Department of Primary Industries

OUT16/28123

Borg Panels Timber Processing Facility (SSD 7016) Comment on the Environmental Impact Statement

STORMWATER MANAGEMENT AND CARPARK

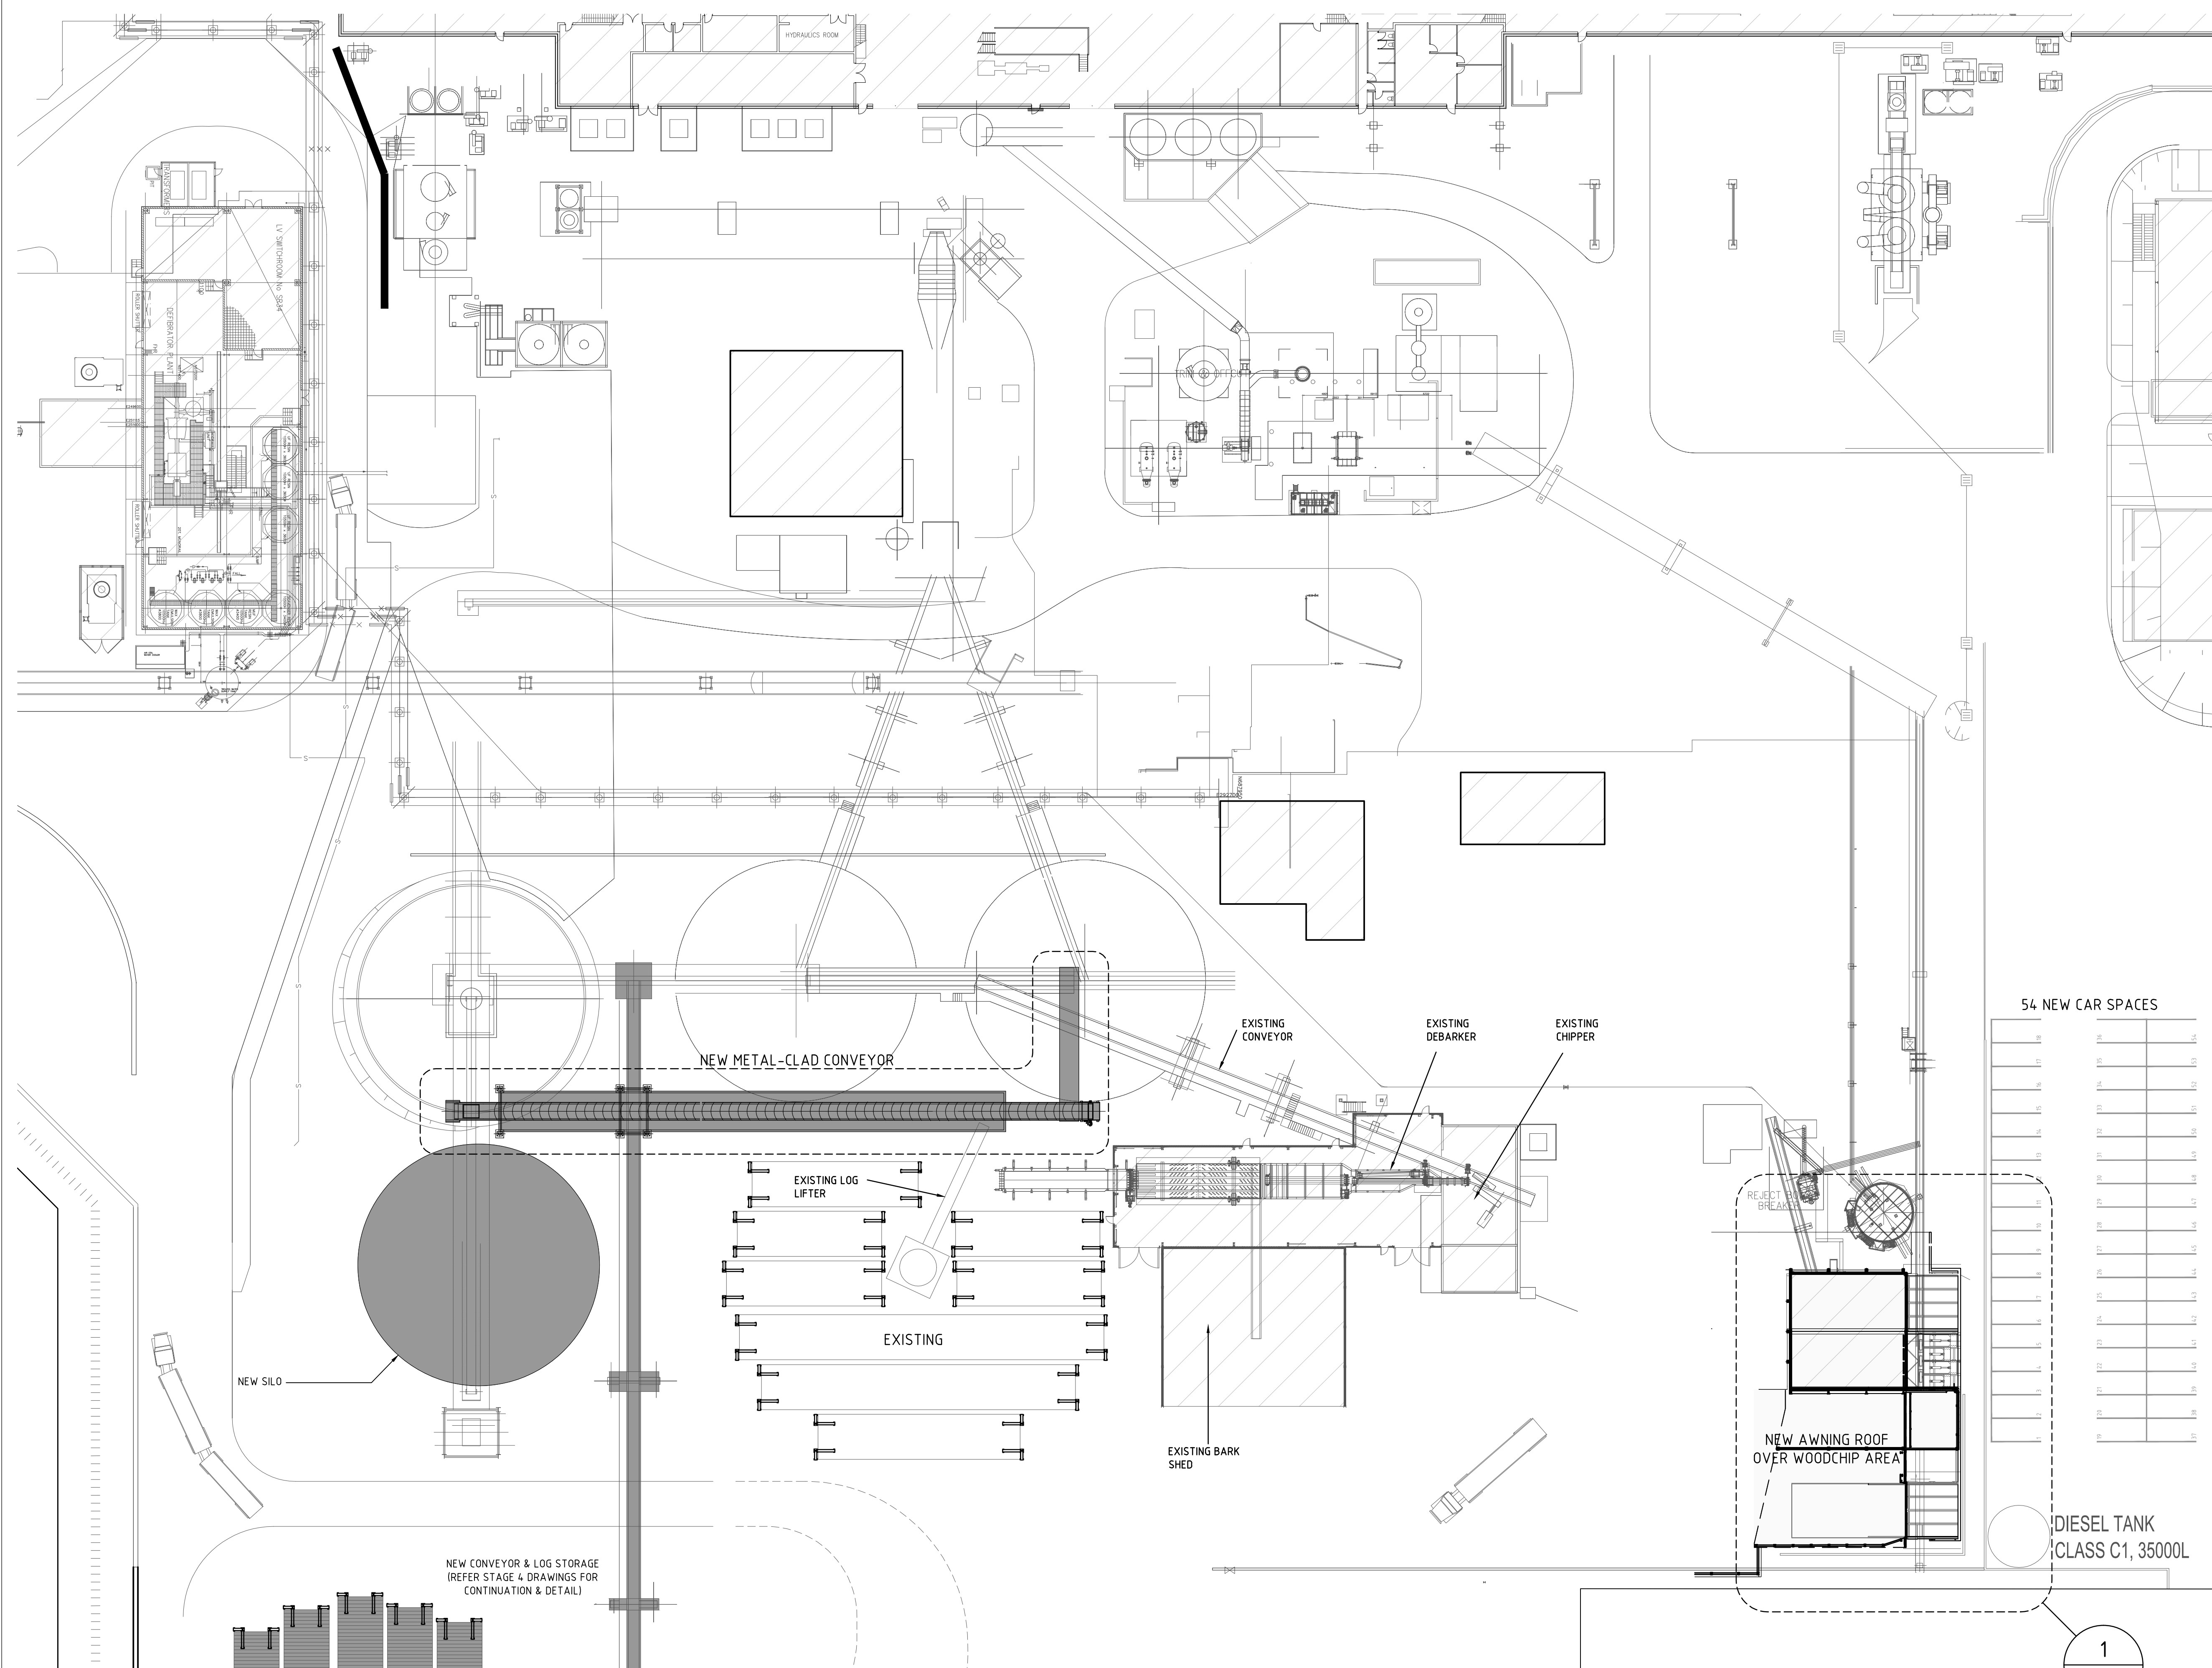
- An additional 6ML stormwater treatment pond is proposed. This pond appears to be in close proximity to the existing watercourse, however the EIS indicates no works are proposed within 40m of a creek line. The proponent should clarify if this pond is outside of the 40m as no specific distance to the high bank of the watercourse has been provided. Works that are proposed within 40m of a watercourse need to be

carried out in accordance with DPI Water's Guidelines for Controlled Activities on Waterfront Land.
